Copper Chase at Sterling Ranch
Traffic Technical Memorandum
(LSC #184990)
December 14, 2021

PUDSP-22-002

Traffic Technical Memorandum

PUD Site Plan

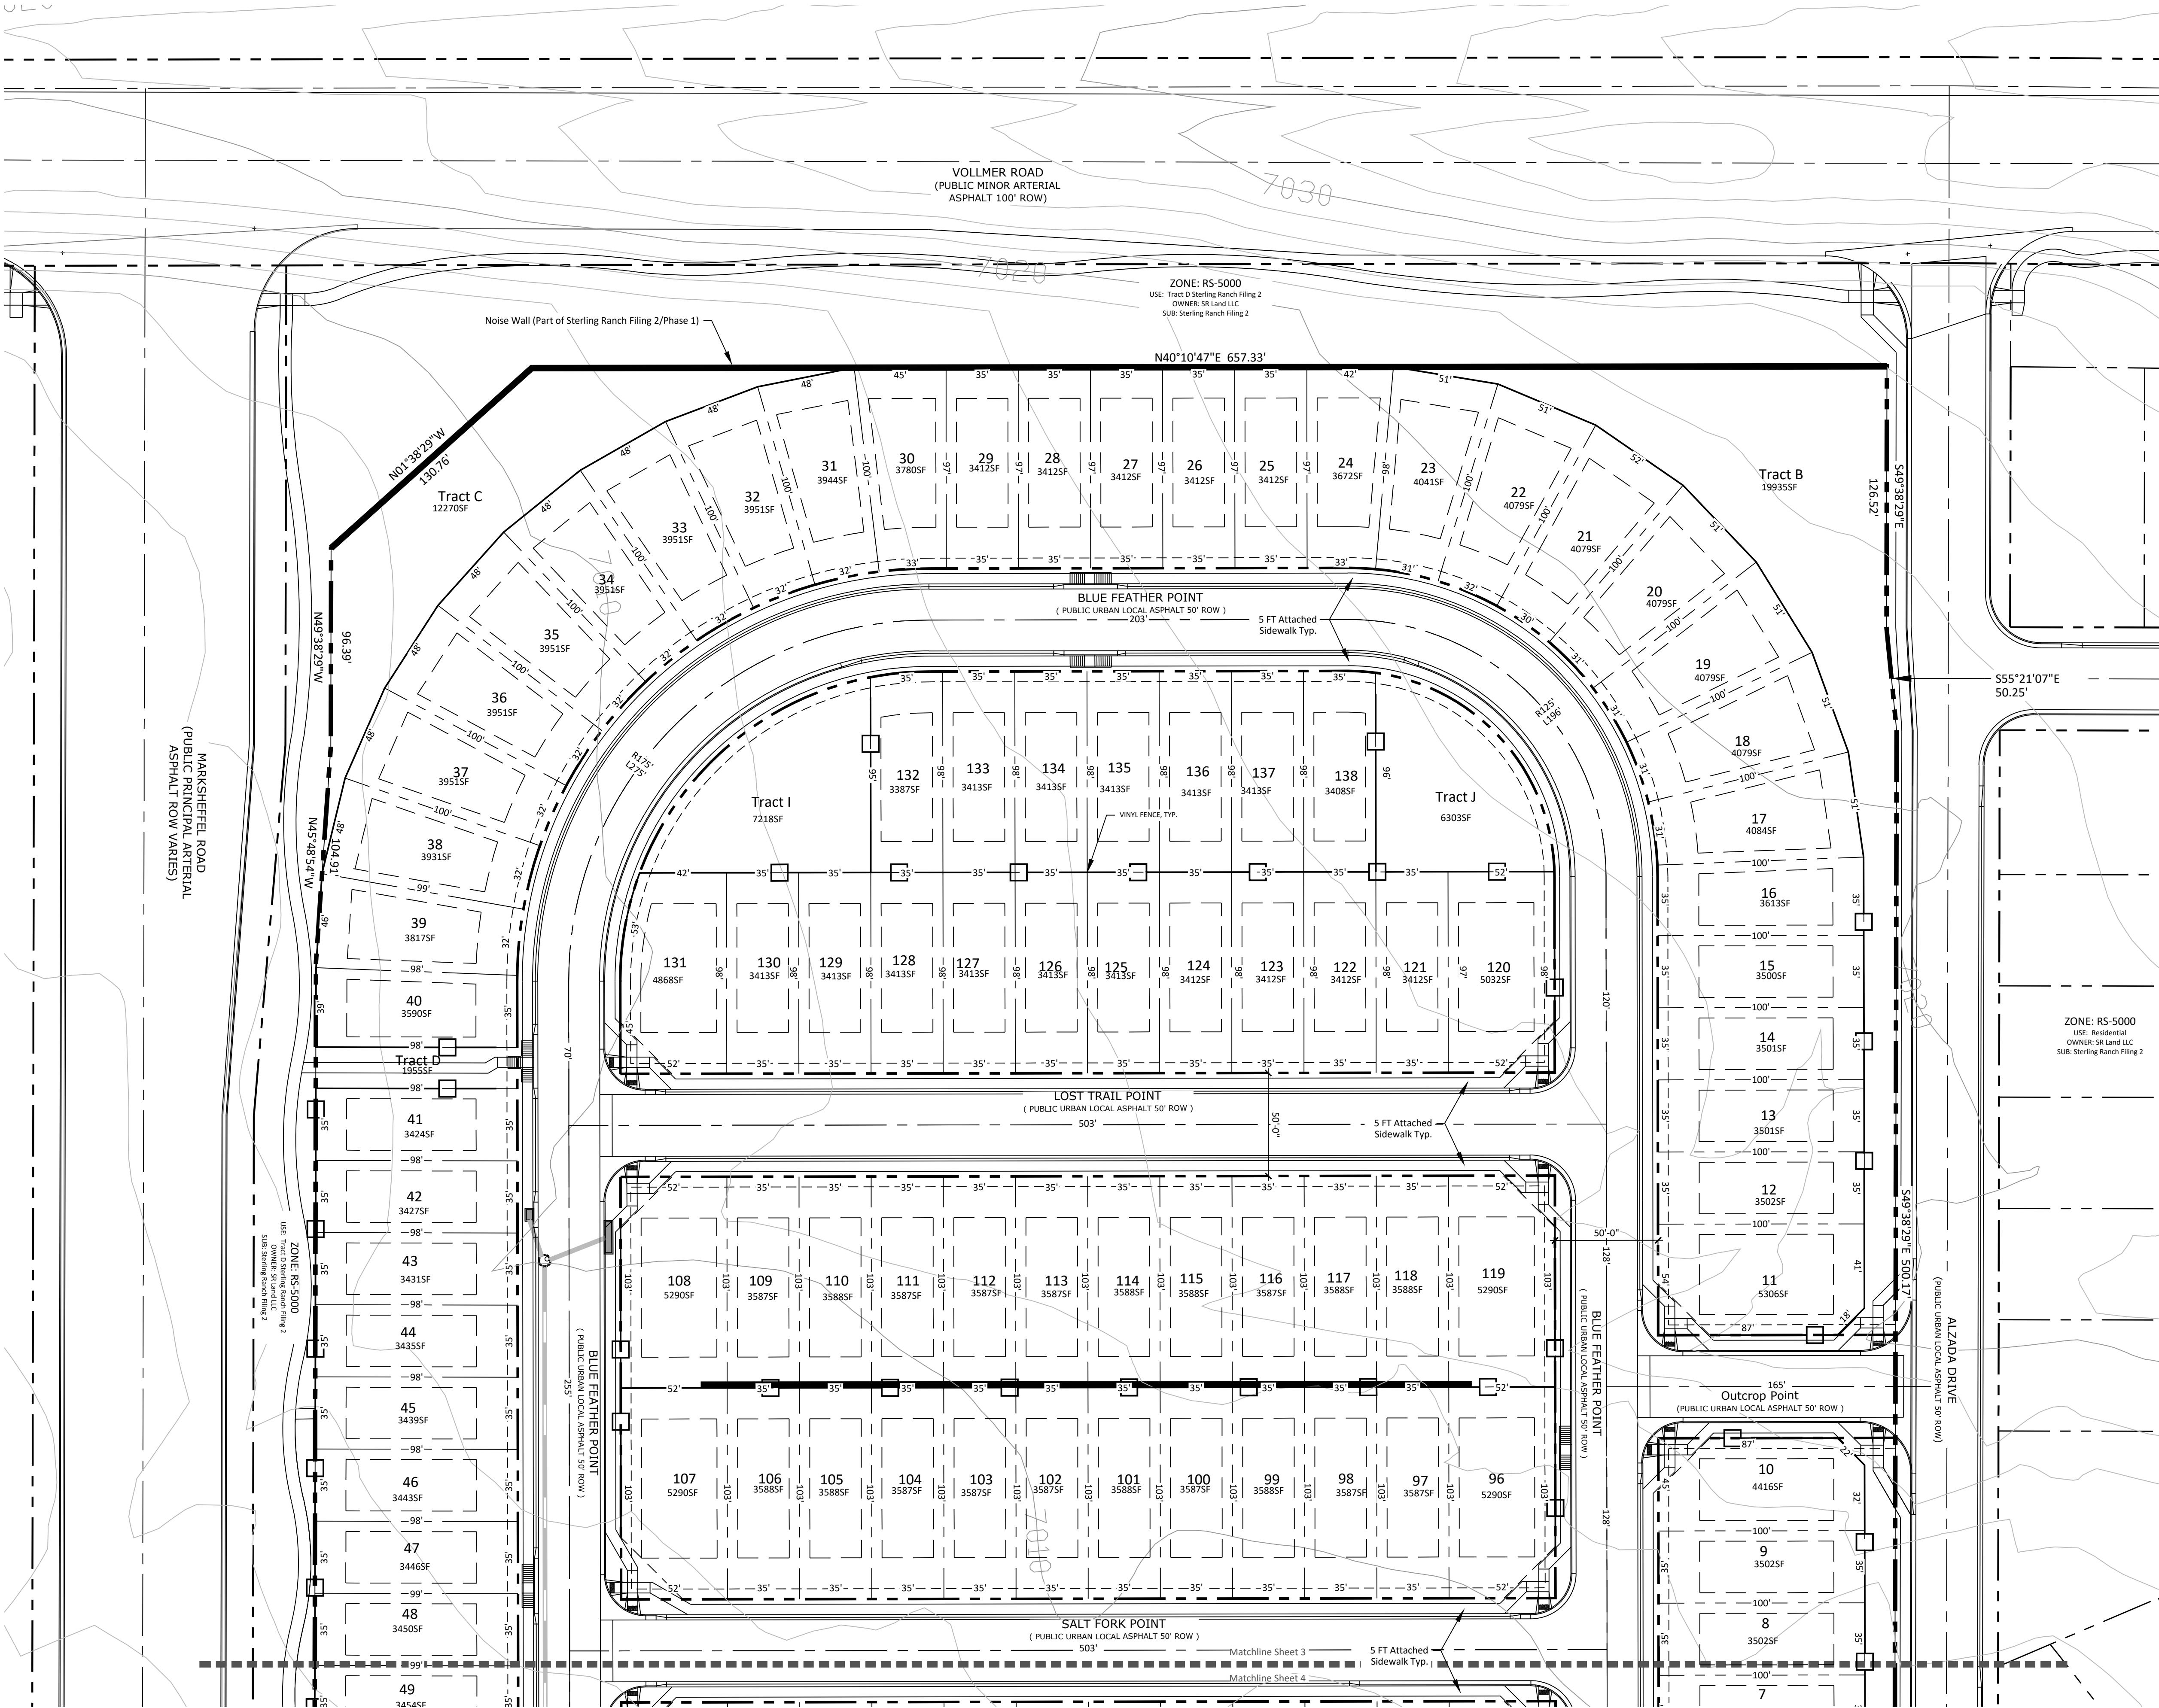
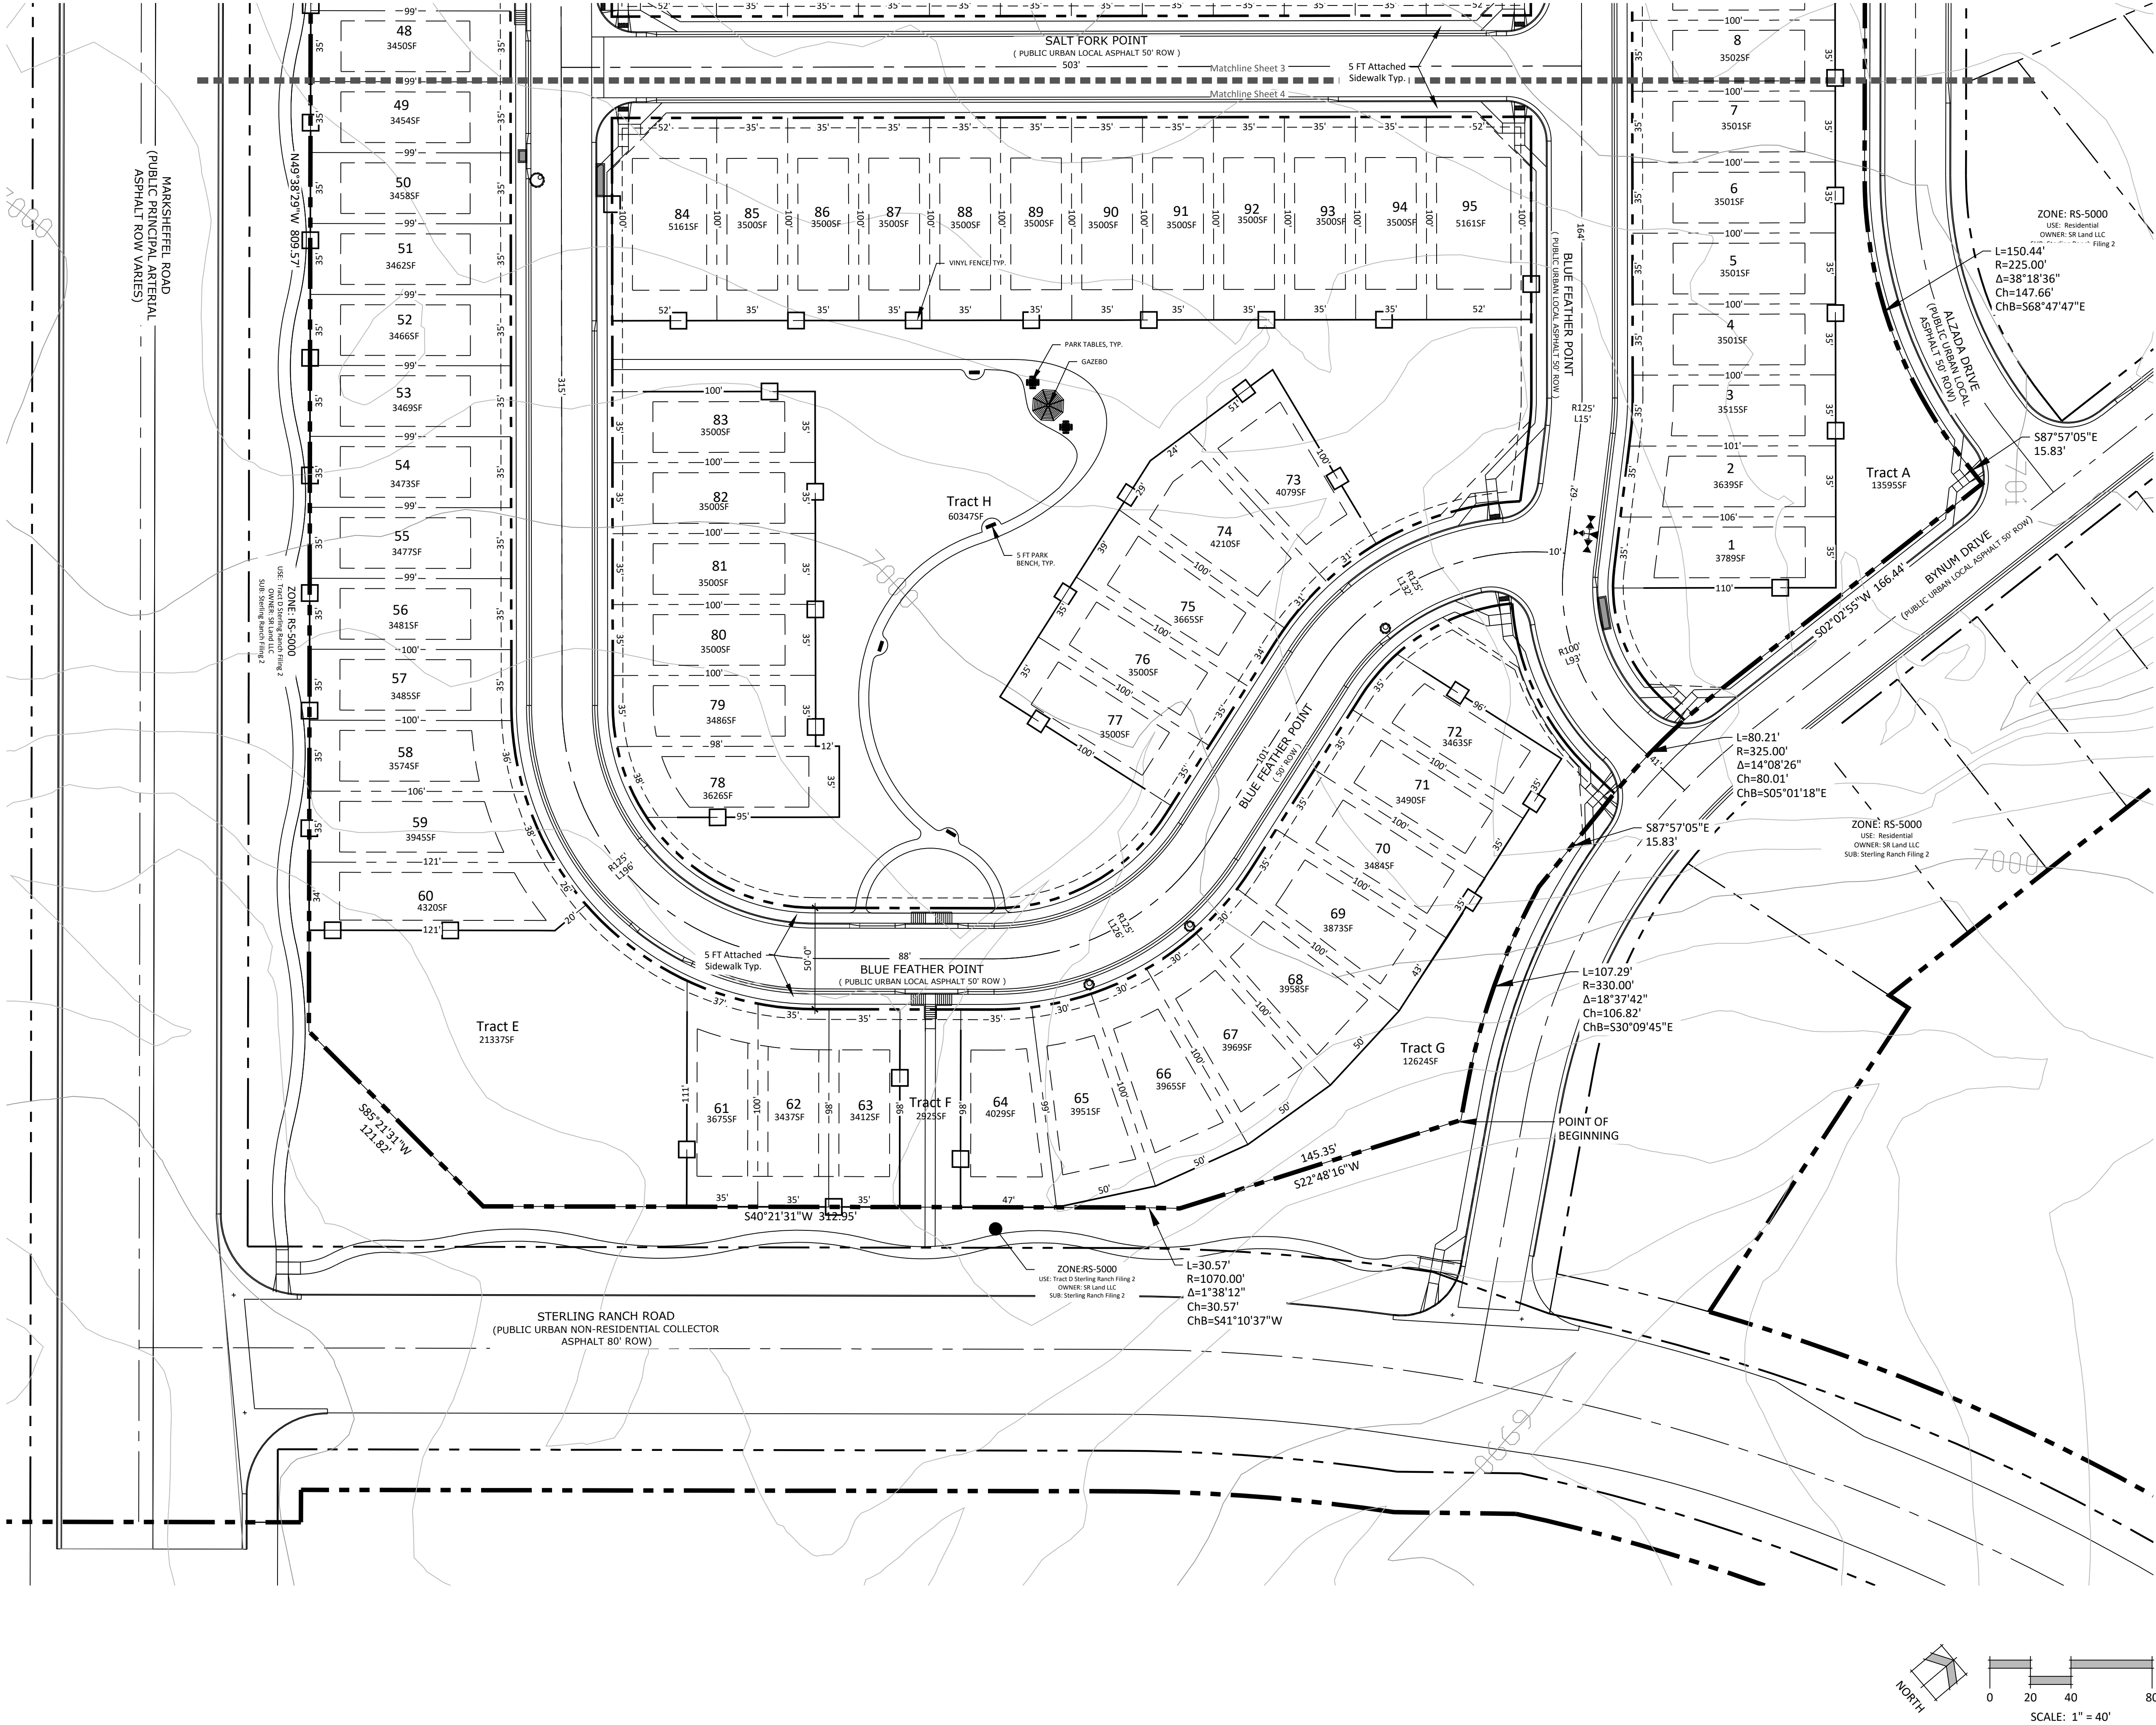
Include classification of adjacent & internal roads shown

Include all street names and public vs private
